City of Albuquerque Stormwater Construction Site Inspection Report

ESC File No.	C18E108	Project Name:	San Pedro Apartments
NPDES Id. No.	NMRI0055P	Location:	9320 San Pedro Dr NE
10/7/2024	Owner	Contractor	
Operator	GTA San Pedro LLC	Tekin Construction	
Contact name & title	Mark Tekin	Carina Sanchez	
e-mail	mark.tekin@tekindevelopment.com	csanchez@tekindevelopment.com	
Contact Phone #		505-933-0476	
COA Inspector	Chancellor English	Start/End Time:	245pm
Construction Phase:	verticals, 66% stabilized		
Type of Inspection:	<input checked="" type="checkbox"/> Regular	<input type="checkbox"/> Storm Event	<input type="checkbox"/> Post Storm Event >0.25" <input type="checkbox"/> 311/Complaint <input type="checkbox"/> Follow Up
Weather at time of inspection?	Clear	Temperature: ~	85
Estimated date of last storm 0.25" or greater	7/22/2024

SHEET:
8

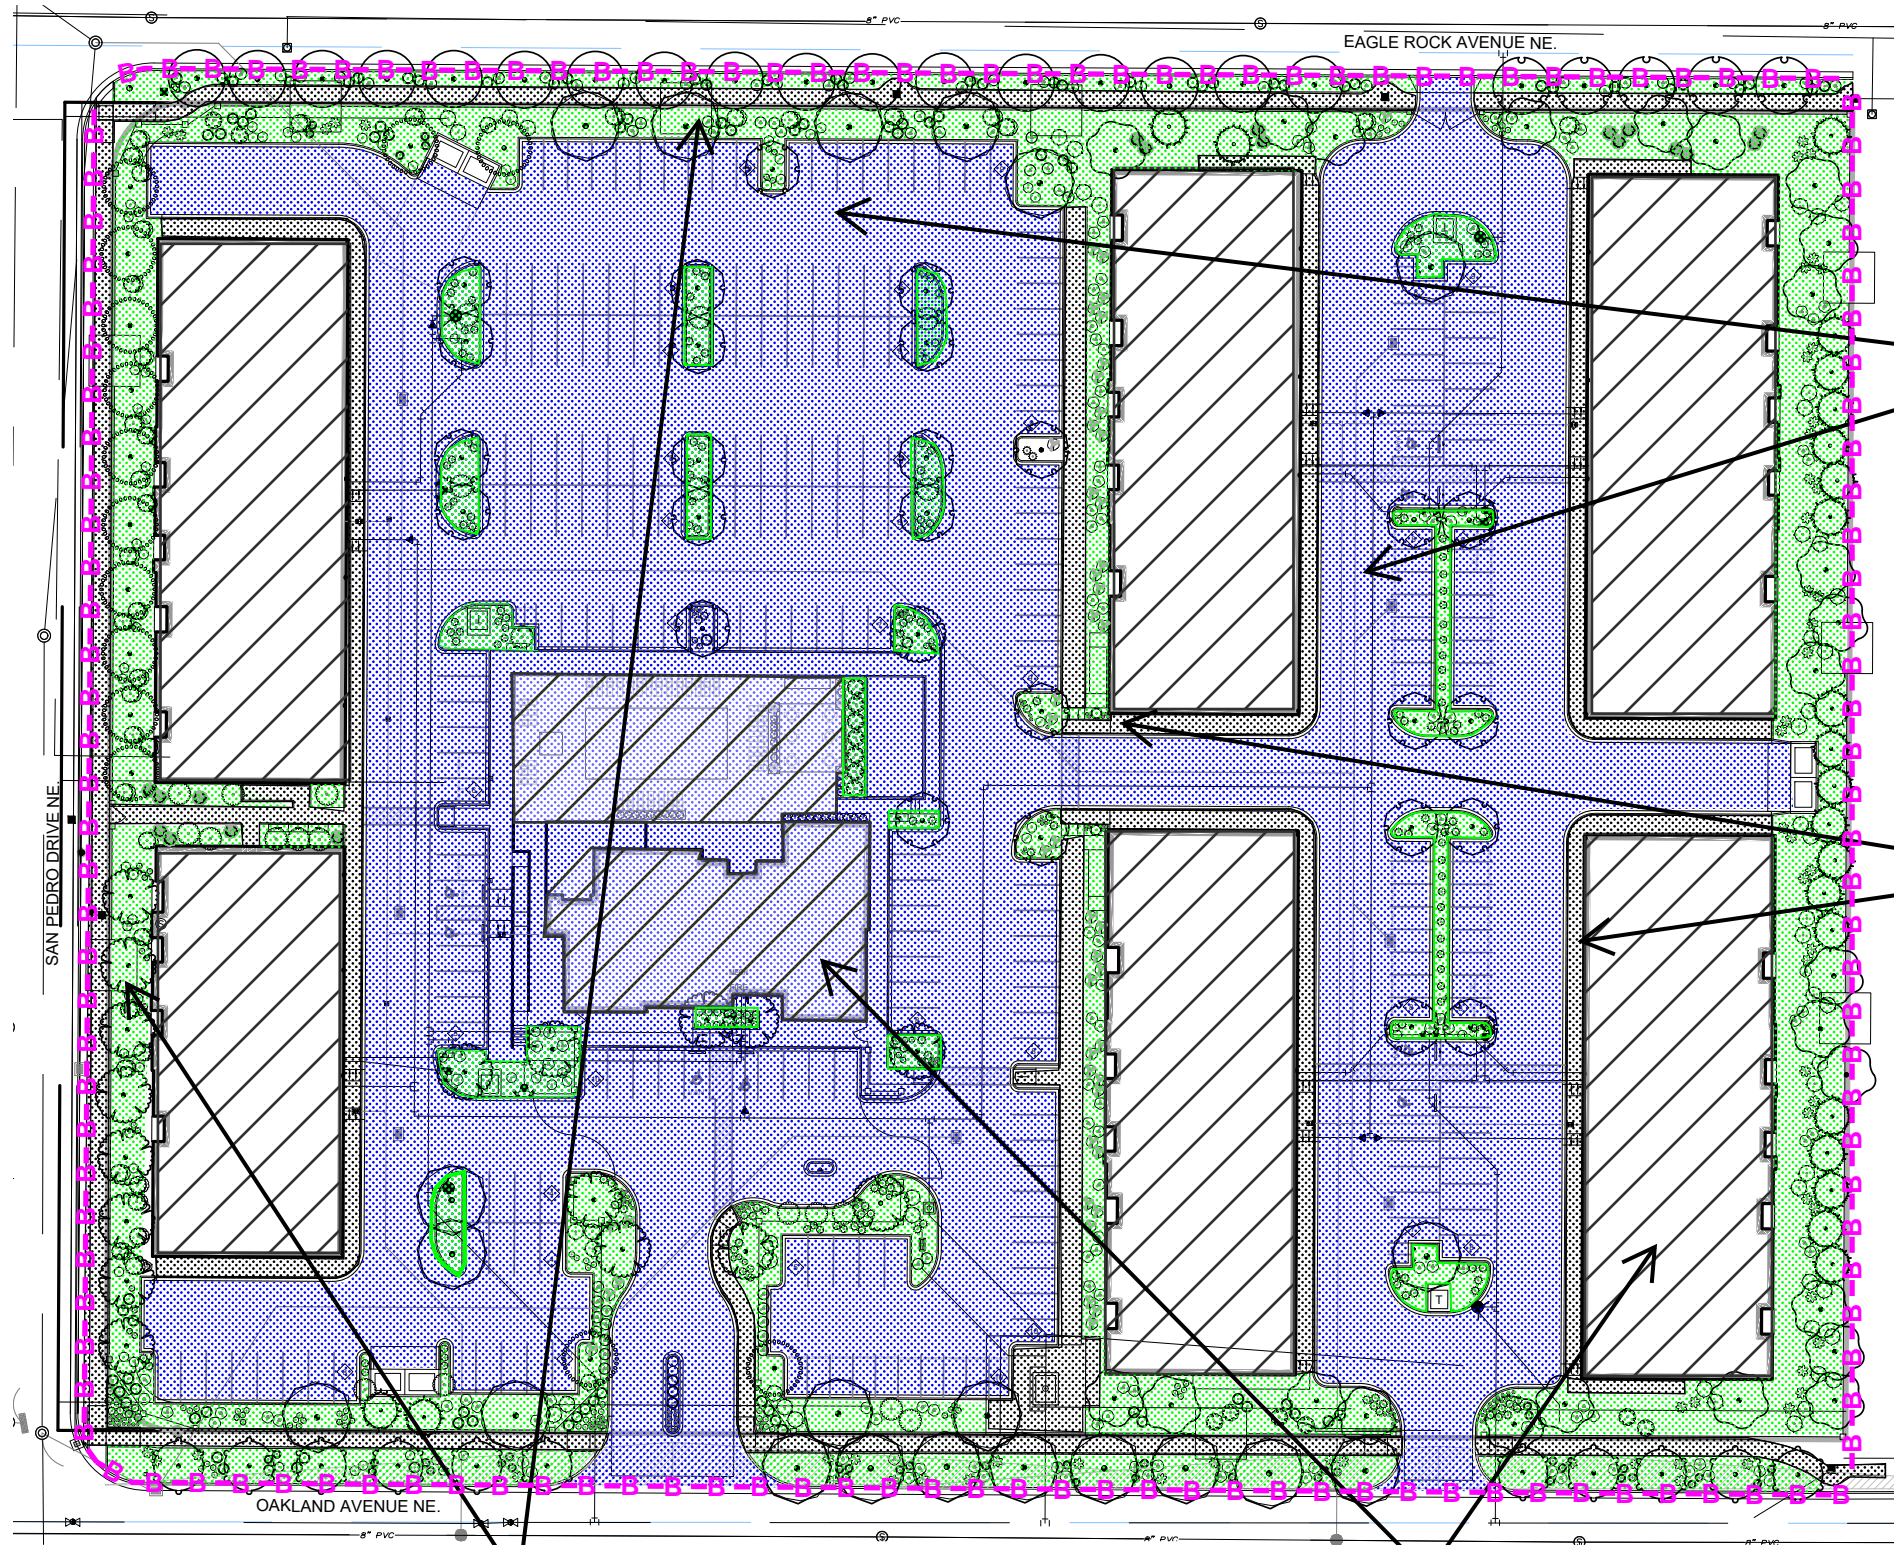
Item Number	Deficiency/ Corrective Action		
1	The SWPPP is not up-to-date. The SWPPP Map does not show the current conditions of the site in violation of CGP Part 7.4.1. The self-inspection reports were not current in violation of CGP Part 4.7.3. Required mitigation: You must modify your SWPPP, including the site maps, within 7 days whenever you make changes to your construction plans, stormwater controls, or other activities at your site that are no longer accurately reflected in your SWPPP per CGP Part 7.4.1. You must keep a copy of all inspection reports at the site or at an easily accessible location, so that it can be made immediately available at the time of an on-site inspection per CGP Part 4.7.3.		
2			
2.1	Discharge off site? (Y/N)	no	
4	Self Inspection Reports	Yes	Latest report Date: 3/11/2024

Notes:	
The SWPPP is located in Unit 2211. The current superintendents are not receiving the inspection reports.
